Re: PA22-015 - Colvin PRD – Technical Review 1

After preliminary review of the above referenced proposal, the Planning Division has the following comment(s):

TO: Emily Morgan, Senior Planner
FROM: Brooke Ensor, NPDES Coordinator
DATE: 12/5/2022
SUBJECT: PA22-015 Colvin PRD

TO: Emily Morgan – Senior Planner
FROM: Jesse Hannahs, P.E. – Traffic Engineering Manager
DATE: December 8, 2022
SUBJECT: PA 22-015 – Colvin PRD

PRELIMINARY ROAD, GRADING & UTILITY PLAN
COLVIN PRD

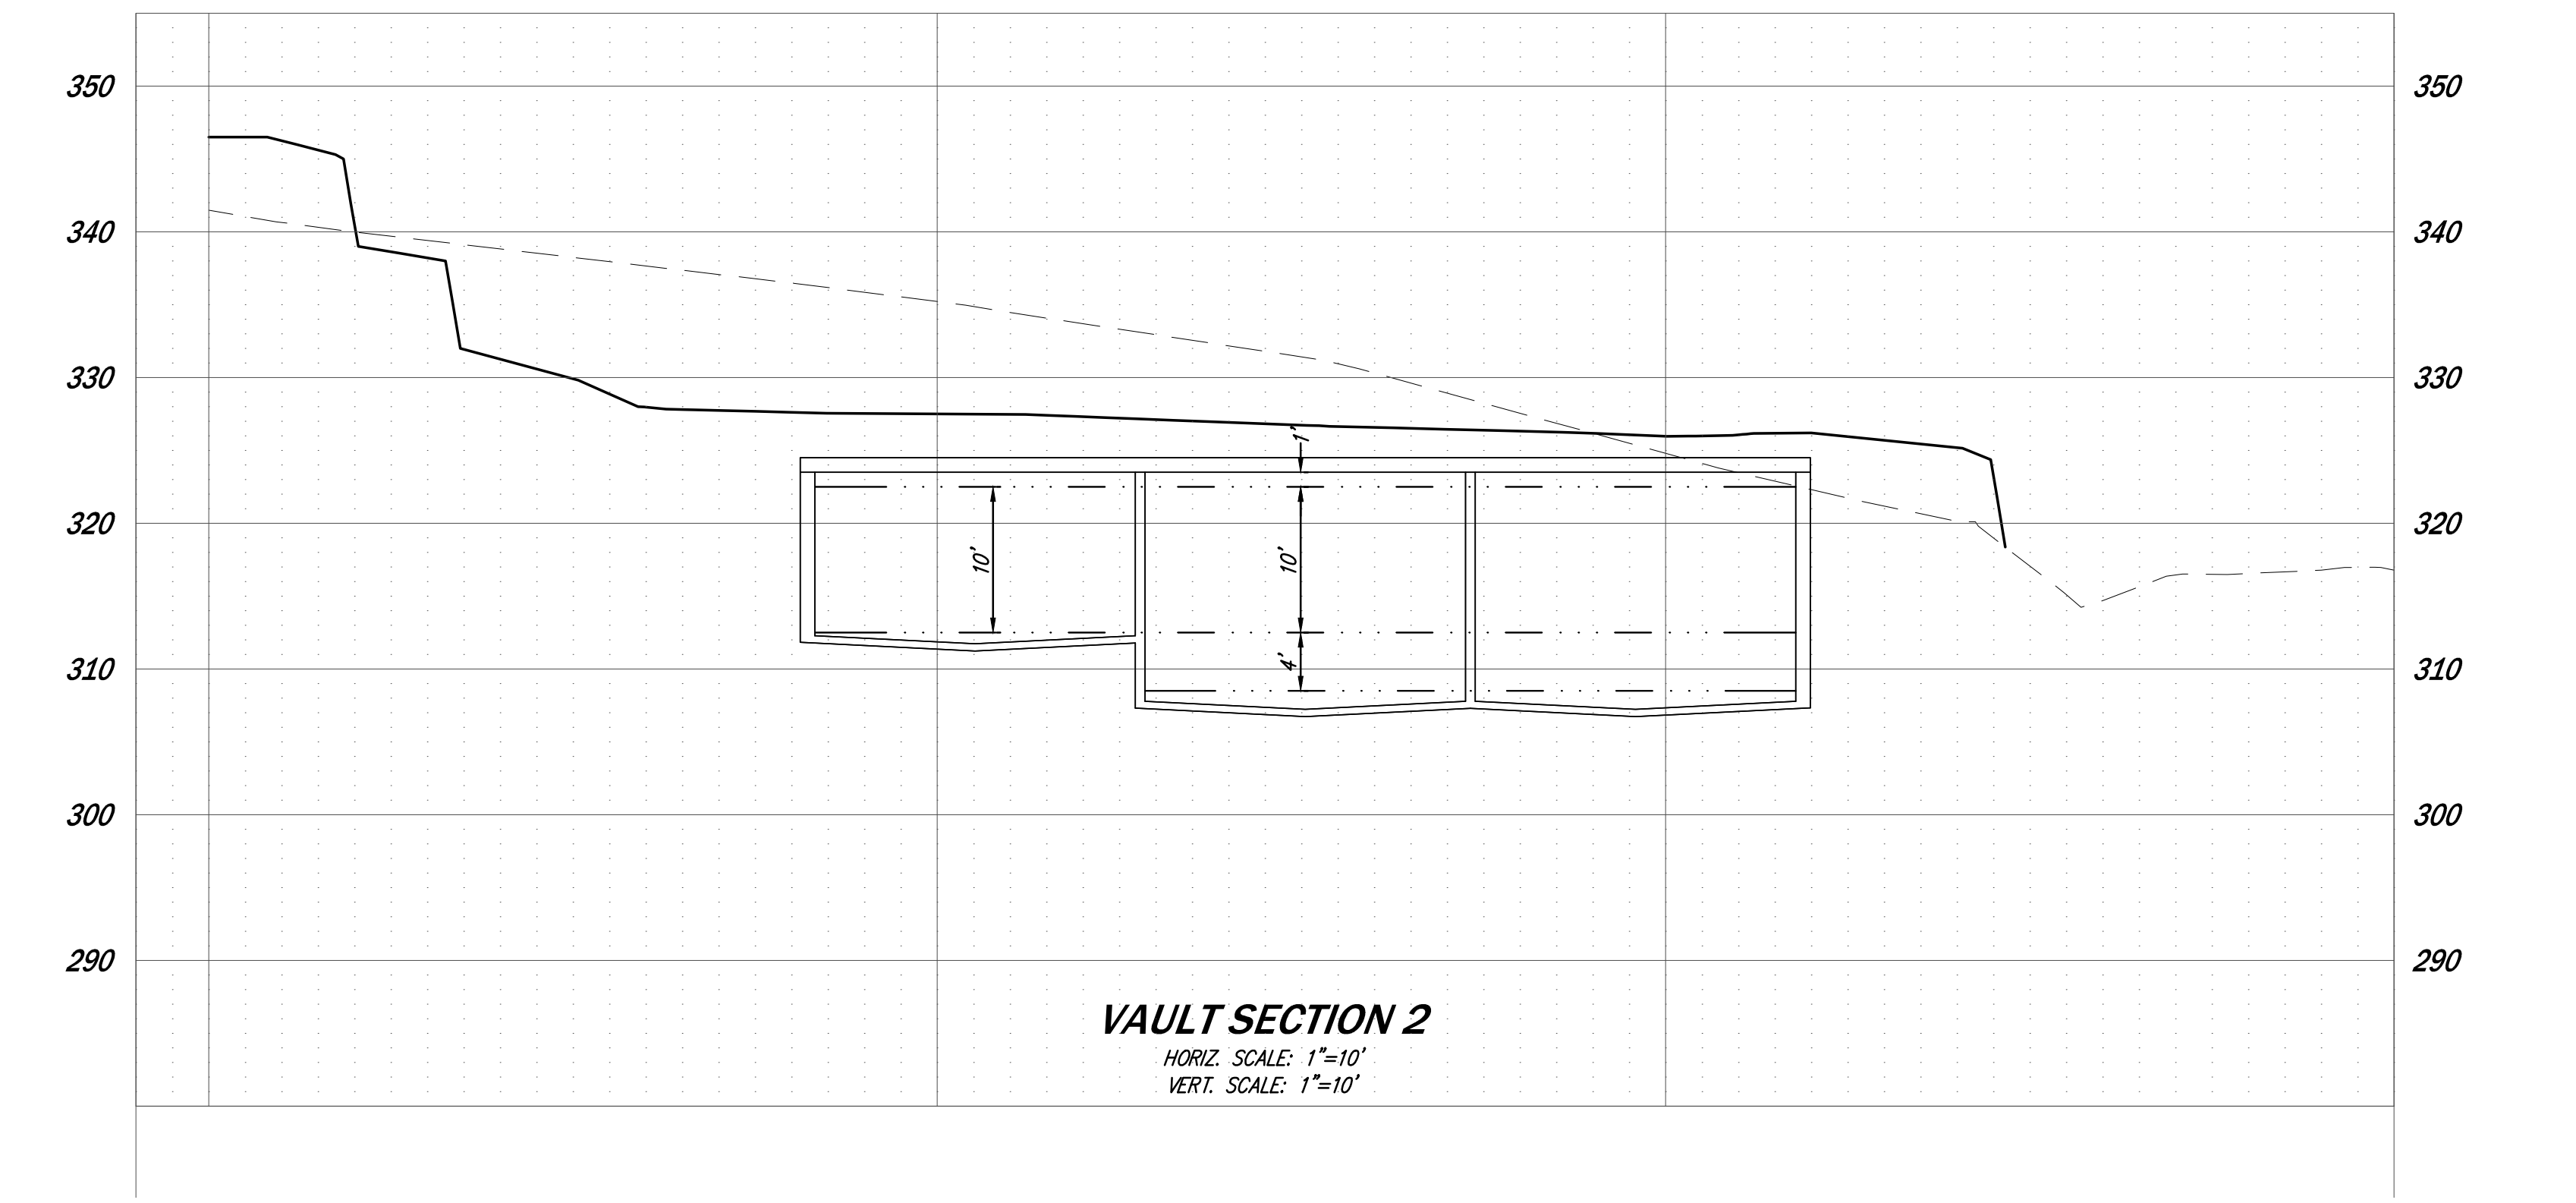
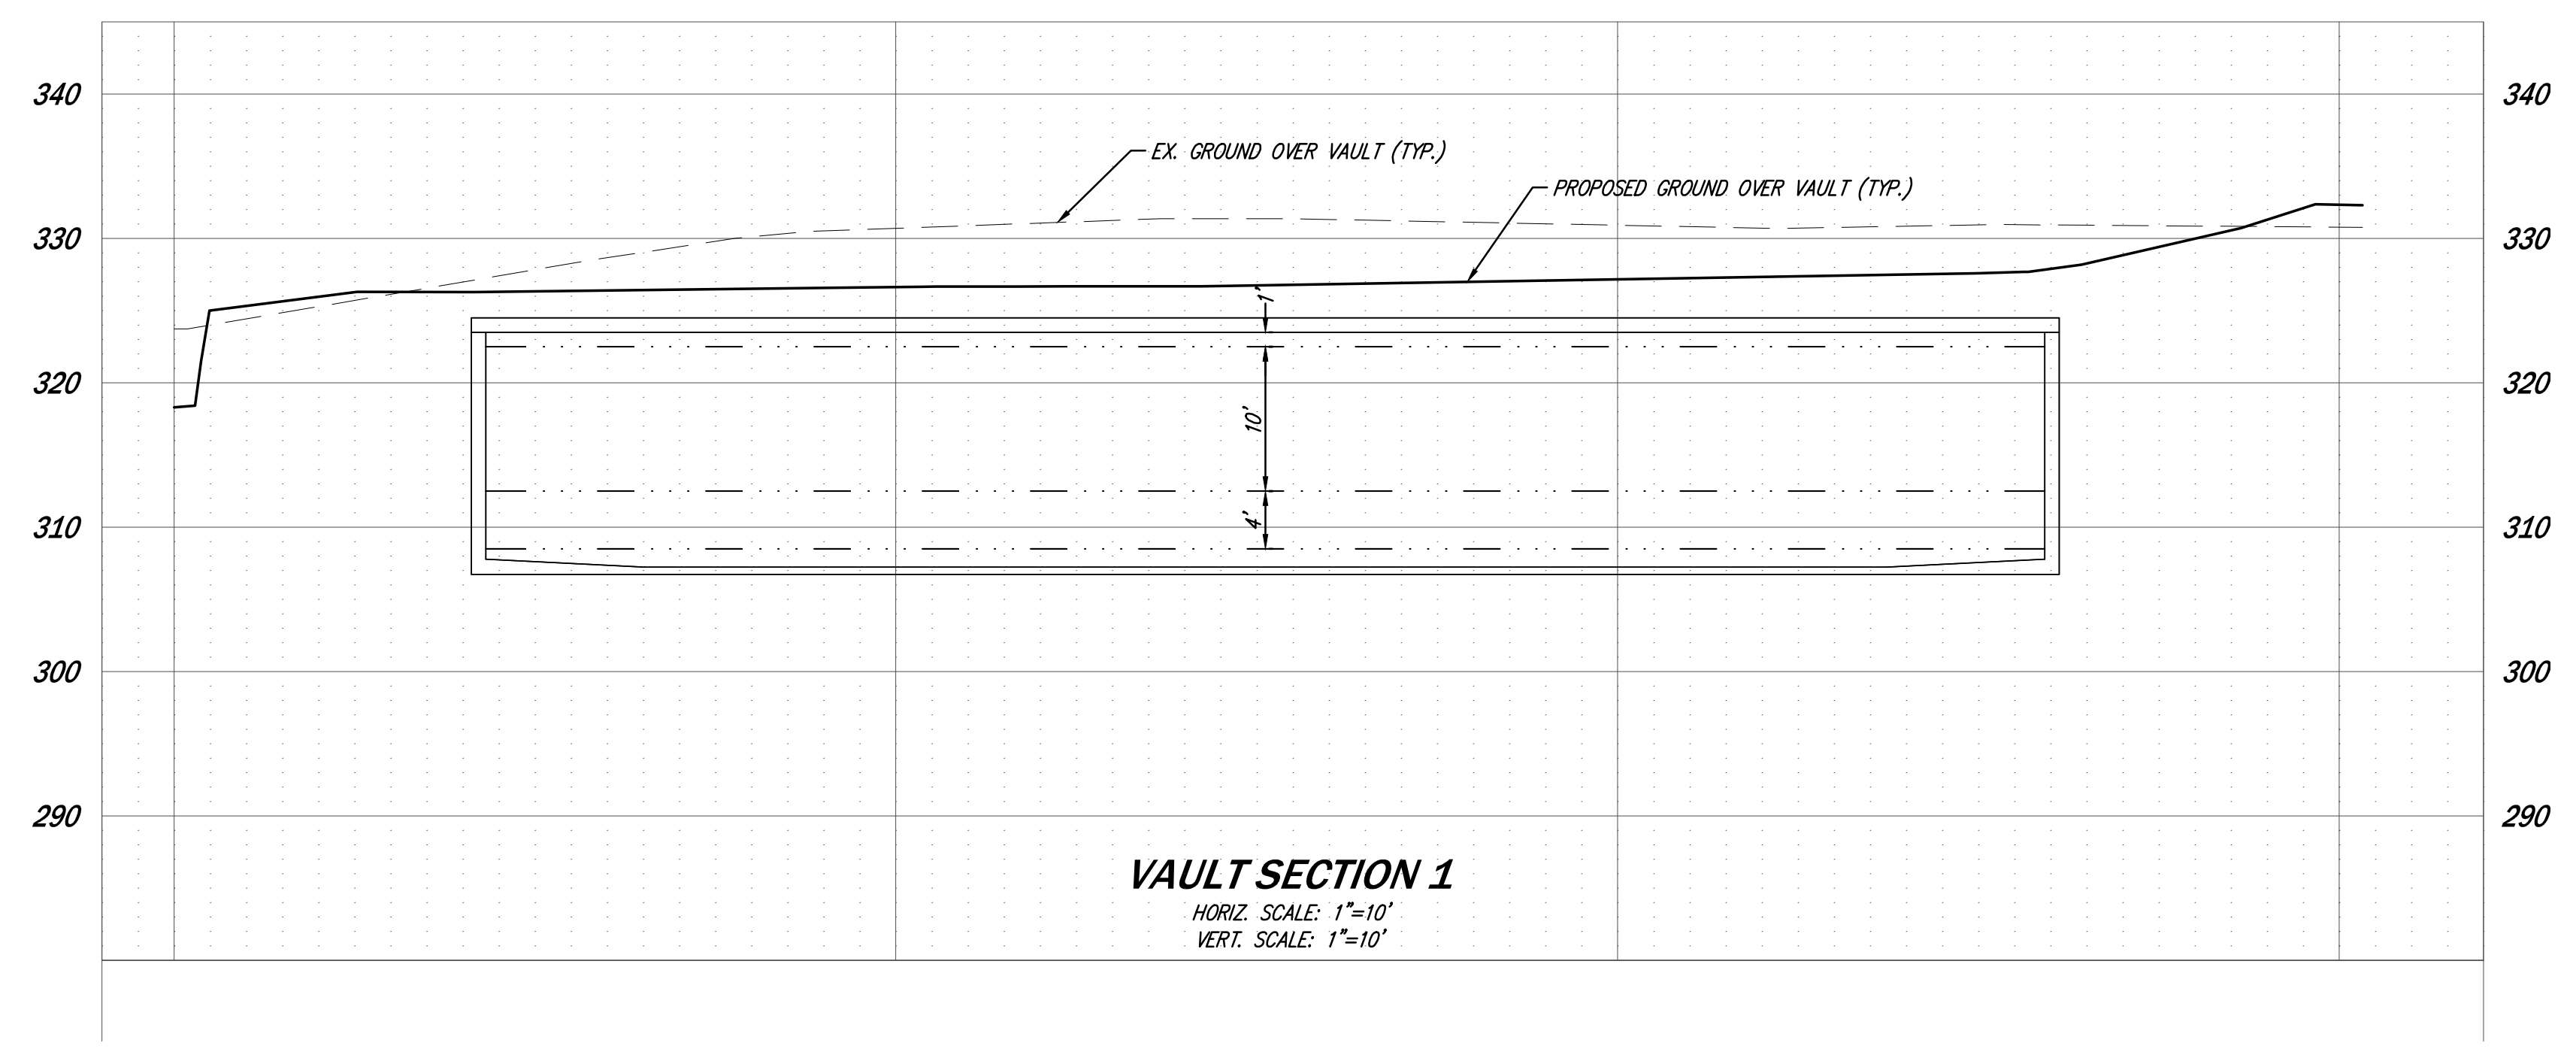
1. The revised civil plans and site plans indicate that shared access is proposed for Lots 21 – 25. Revise plans to identify the proposed driveway locations off of Tracts C and D. As noted in the applicant's resubmittal letter, driveway drop locations are identified on C3.01, however, with the topography layers, the driveway locations are difficult to view.

PRELIMINARY ROAD & VAULT SECTIONS
COLVIN PRD

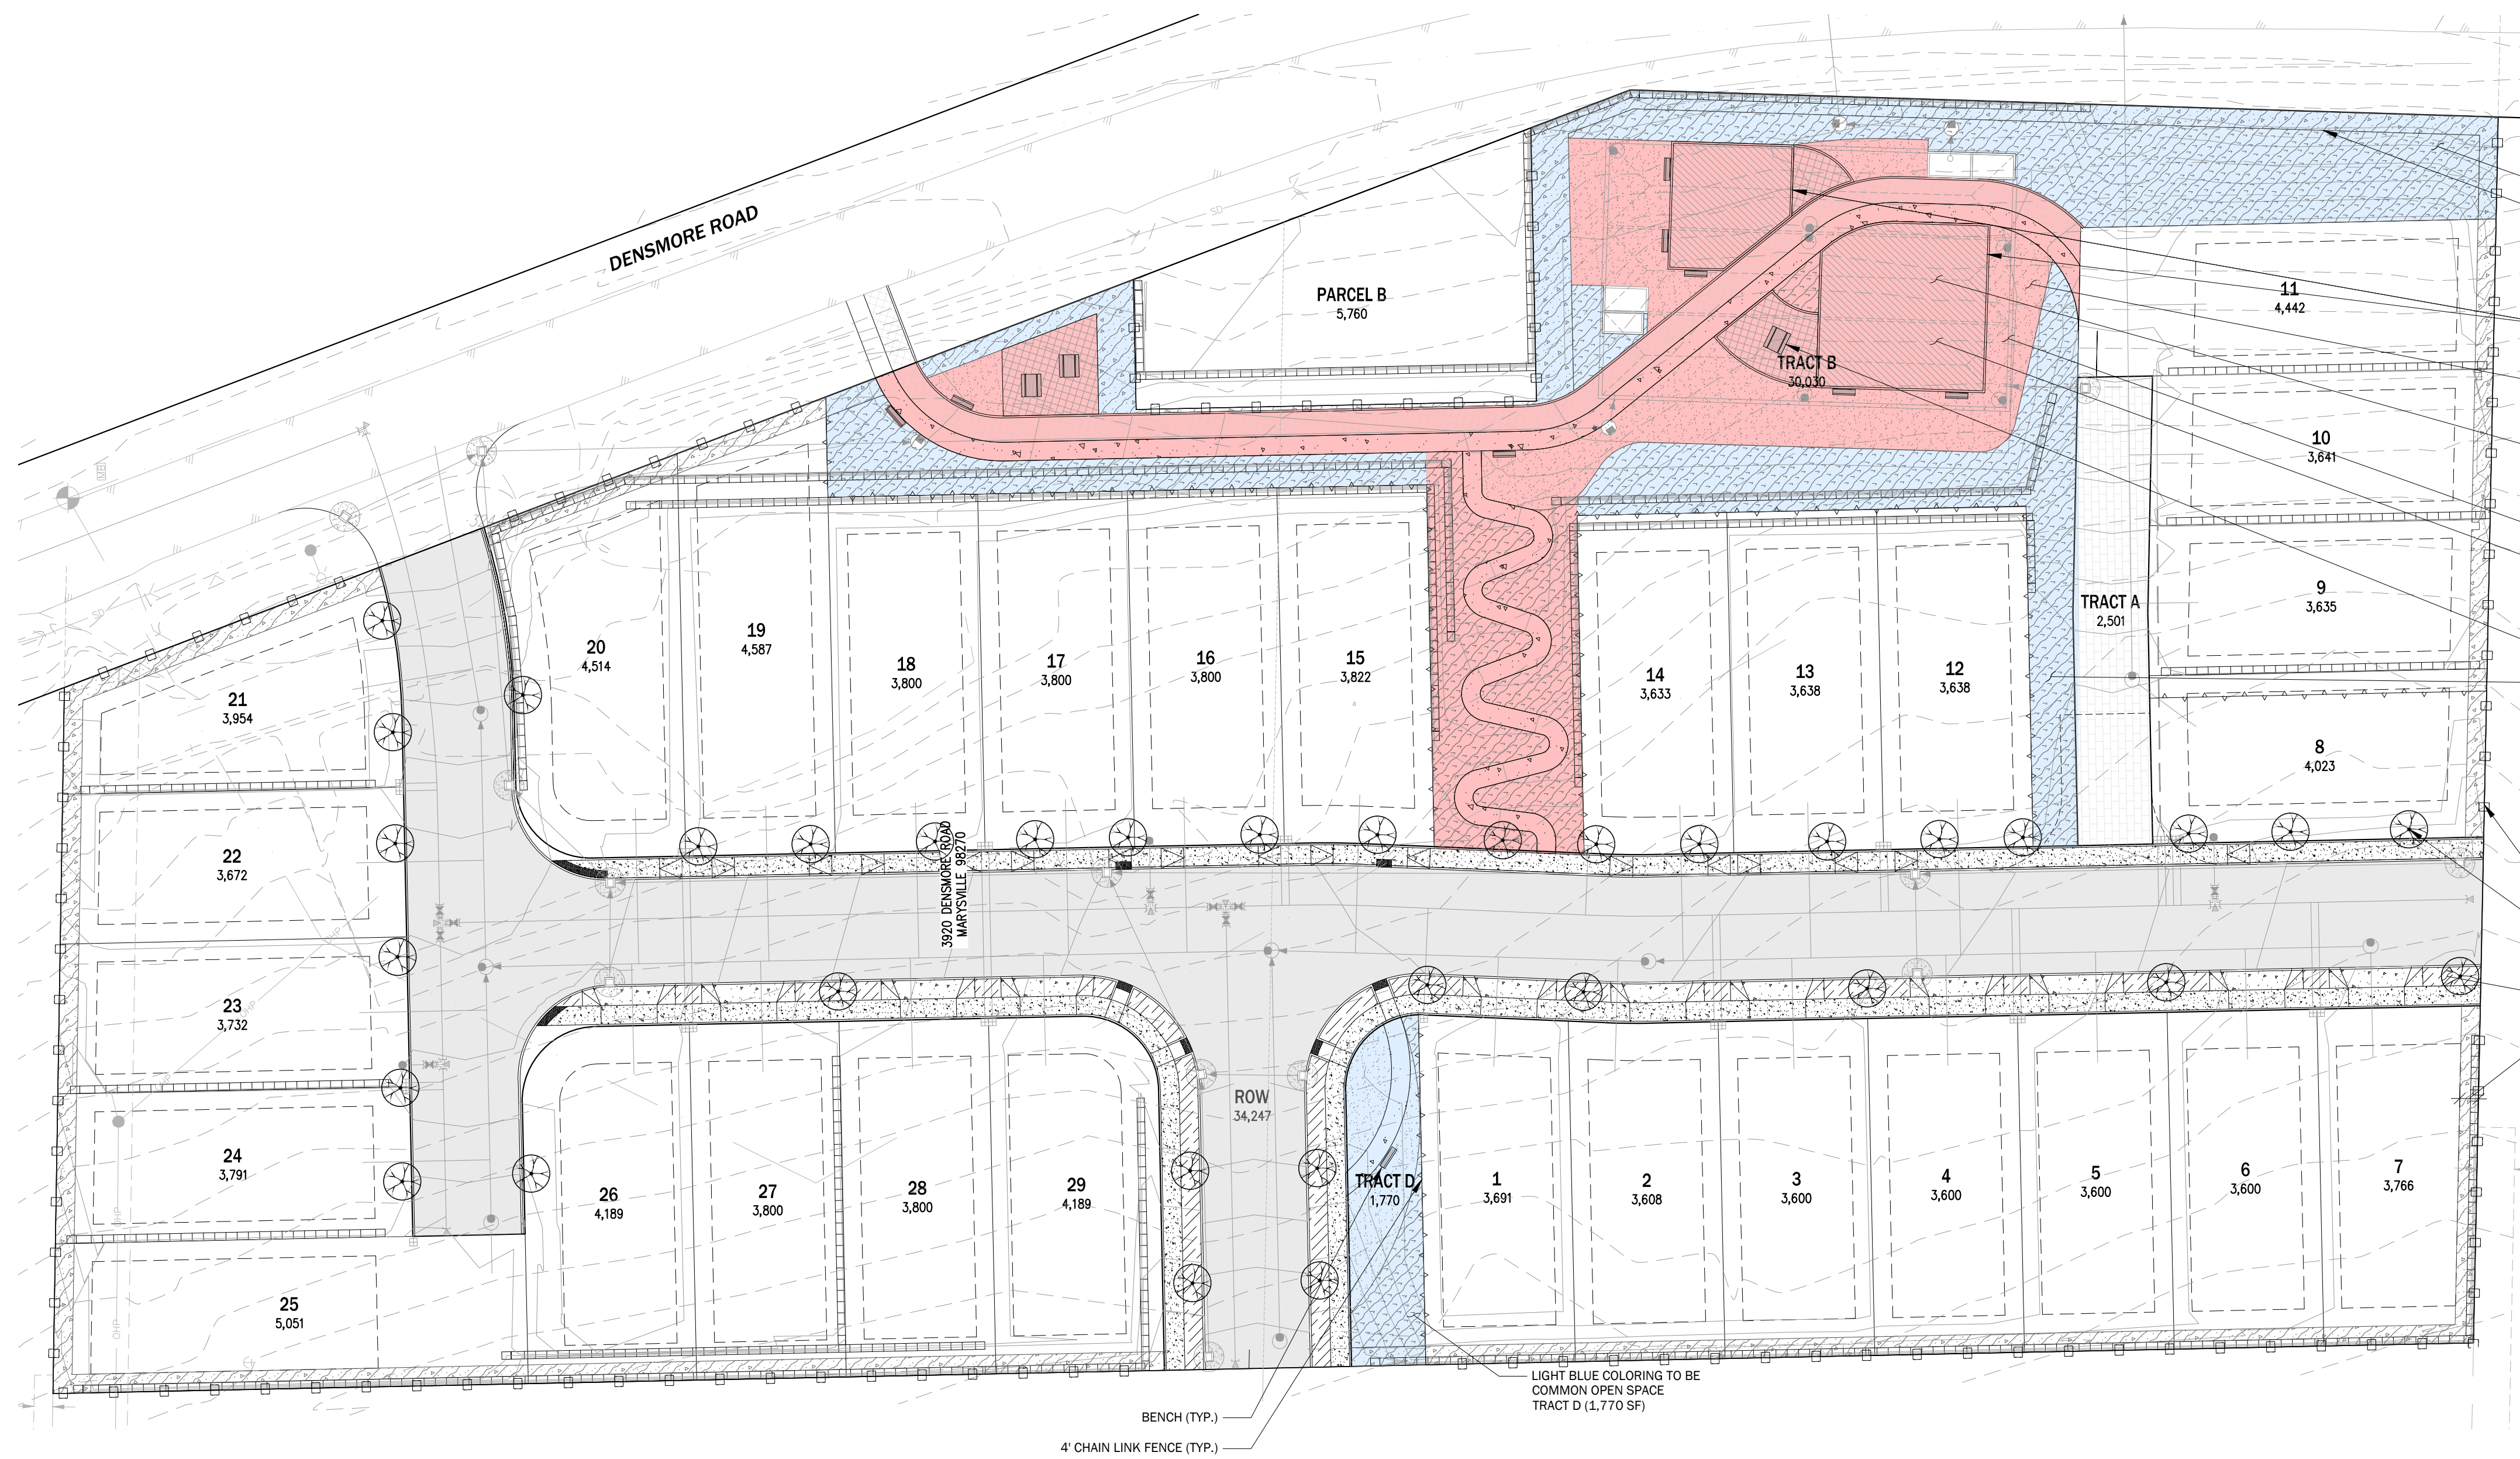
1. The access drive to the vault is not adequate for a vactor truck to perform maintenance. Please use a reinforced surface, like the grasscreeet for the whole width of the drive. Please include details on the plan notes or in the drainage report to demonstrate that the material will hold up under the weight of a loaded truck.
2. Please check with Engineering to determine if the vault access road can come from Densmore Rd.
3. The access road is rather long, with walls on either side. A turn around at the end may be necessary.
